Rezoning Transportation Analysis

Petition Number: 2020-160

General Location Identifier: Tax ID 10102101

Date	Description
12-28-20	First Review (WB)
01-21-21	Second Review (WB)

Aldersgate Rezoning #2020-160
3800 Shamrock Drive
Charlotte, NC 28215
Date: 10/02/2020 - Rezoning Submittal
Project ID: 17048
RZ-01

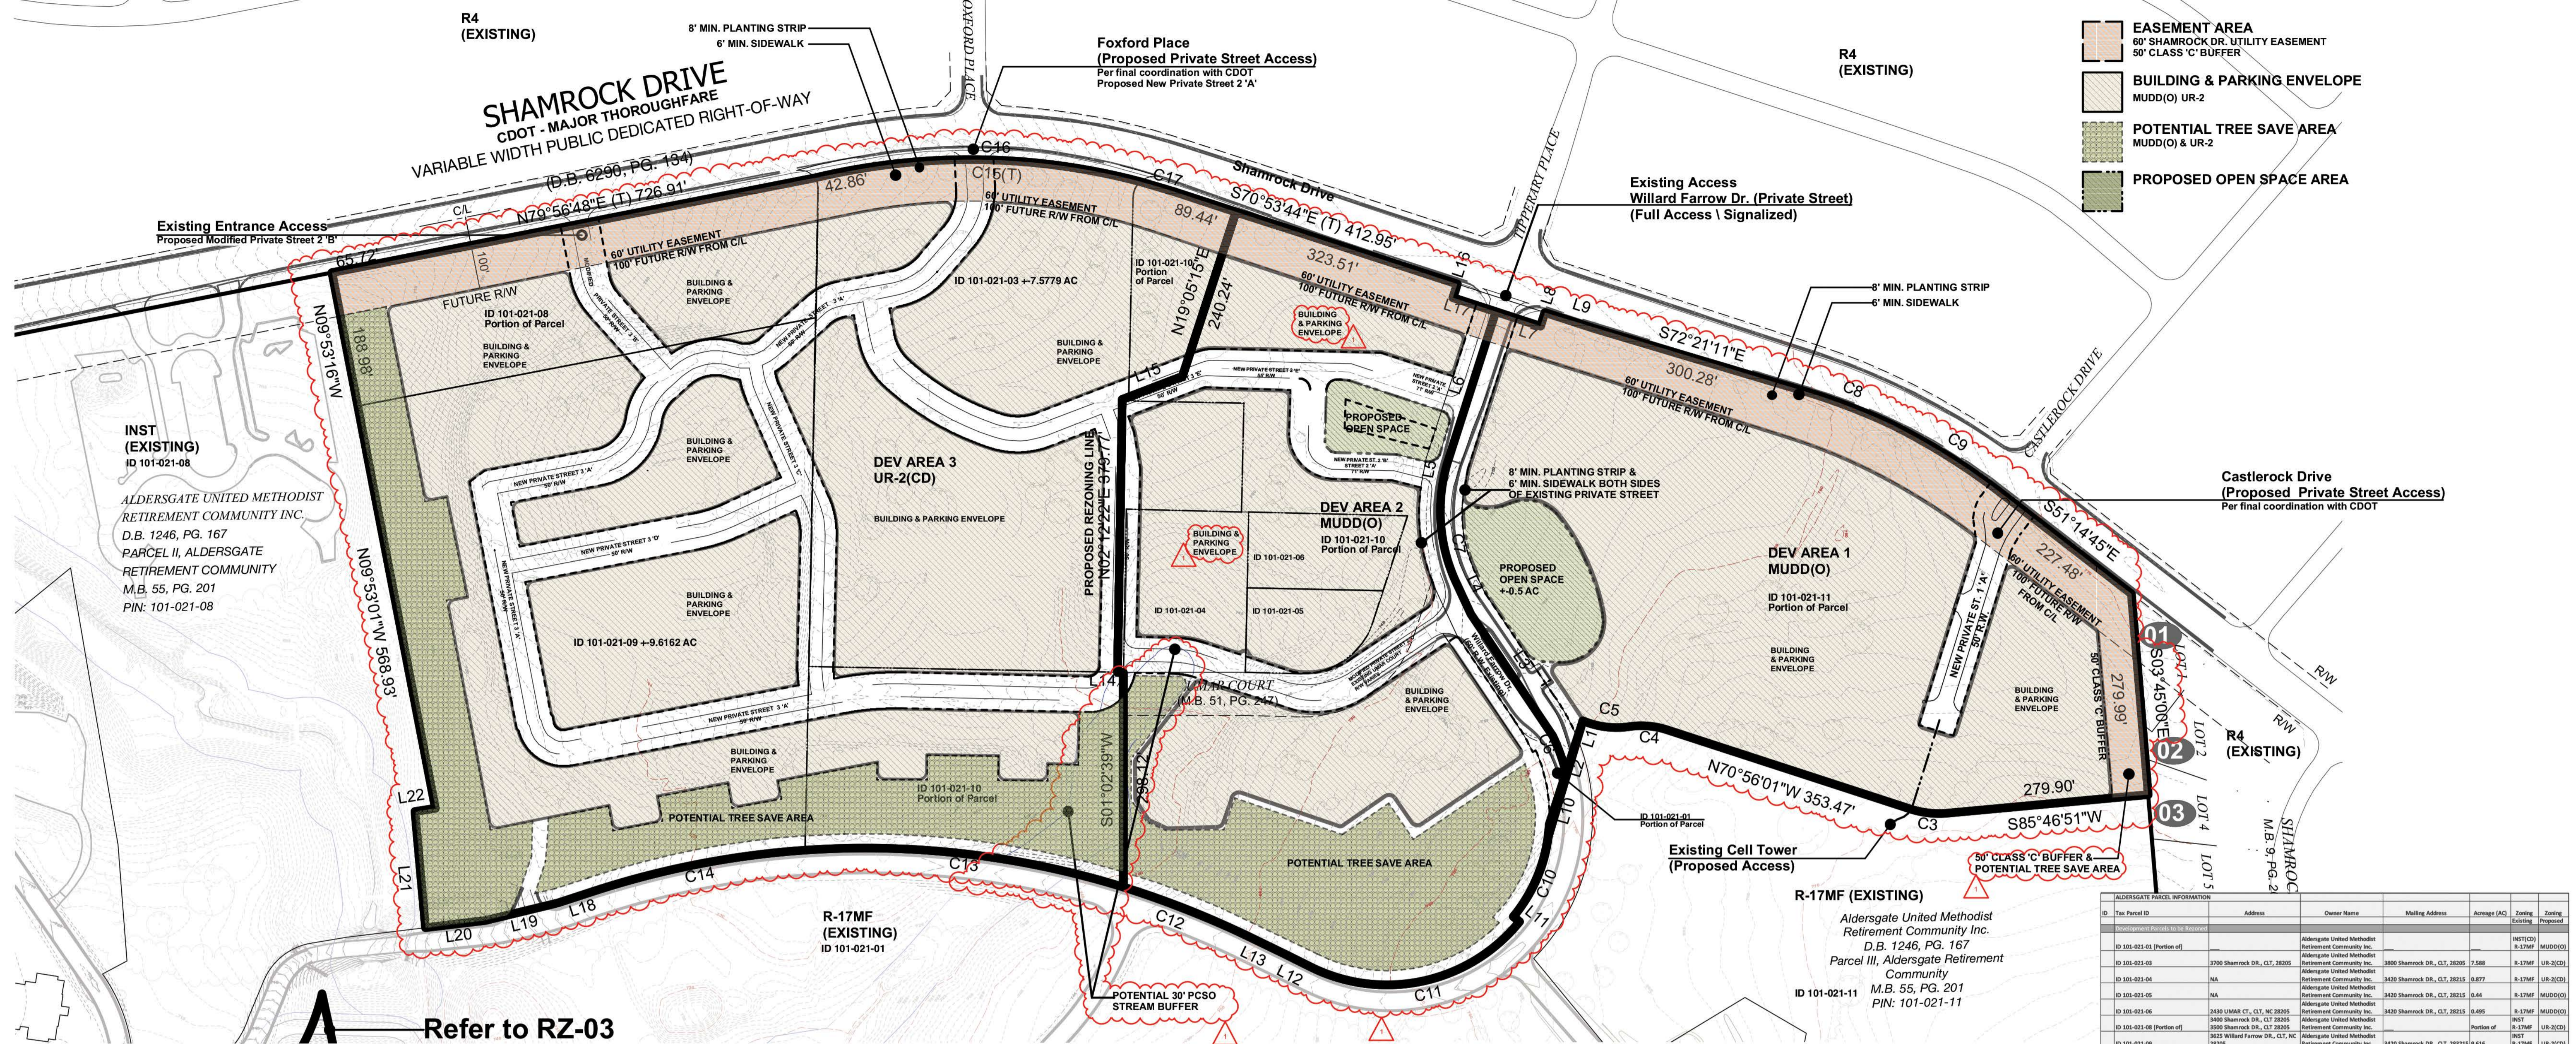
- ~~2. Revise site plan and conditional note(s) to commit to dedicating 50-foot of right-of-way (minimum) from the Shamrock Drive centerline. Label and dimension the right-of-way from the road centerline.~~
3. Revise site plan and conditional note(s) to commit to providing pedestrian and bicycle access through the site, from two existing public street stubs (Dowling Drive and Seaforth Drive) and the Edsel Place cul-de-sac, to Eastway Drive, Shamrock Drive and the Briar Creek Greenway. The pedestrian and bicycle connectivity is consistent with the Eastland Area Plan recommendations, the Charlotte BIKES Policy and the Charlotte WALKS Policy.

Add a conditional note stating that “Pedestrian and Bicycle access to and from Parcel 10102101 by the way of Dowling Drive, Seaforth Drive and Edsel Place, shall be provided.”
